# SADDLEHORN RANCH - FILING 3

## GRADING AND EROSION CONTROL PLANS

EPC STORMWATER REVIEW COMMENTS  
IN ORANGE BOXES WITH BLACK TEXT

SADDLEHORN RANCH - FILING 3
 OVERALL SITE MAP
 SHEET 4 OF 13
 JOB NO. 25142.05

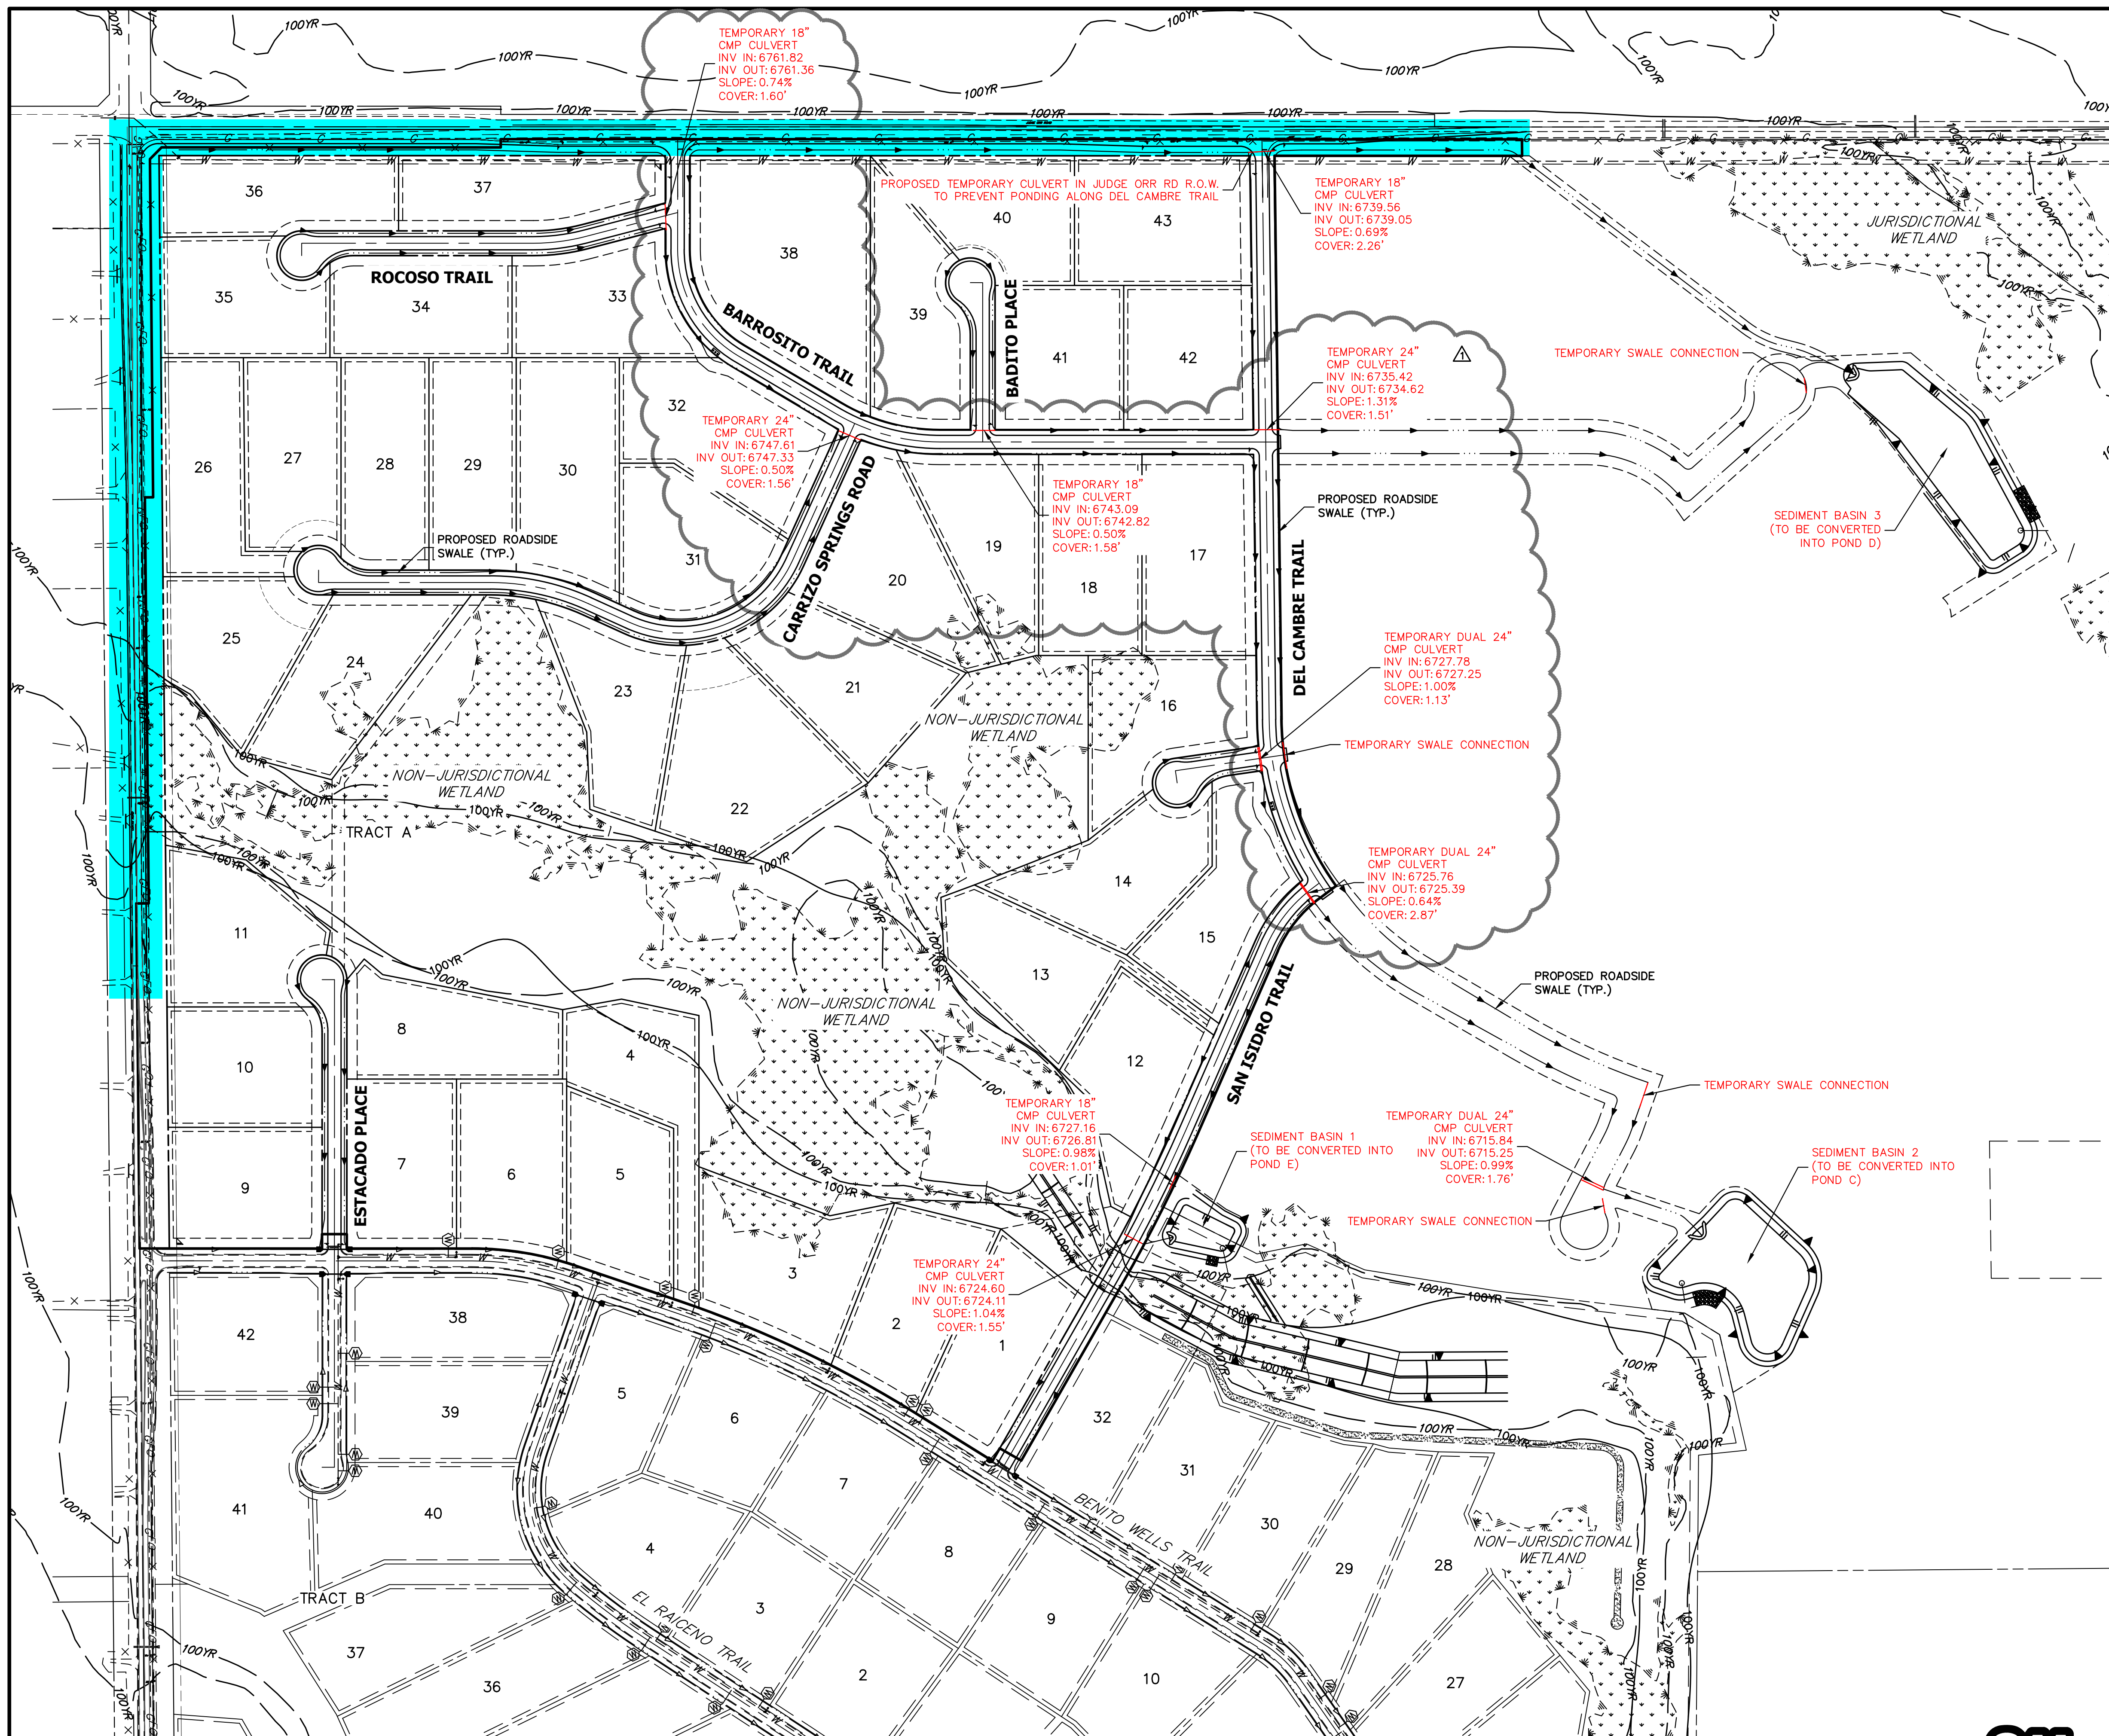
Include Lot numbers

Label tract
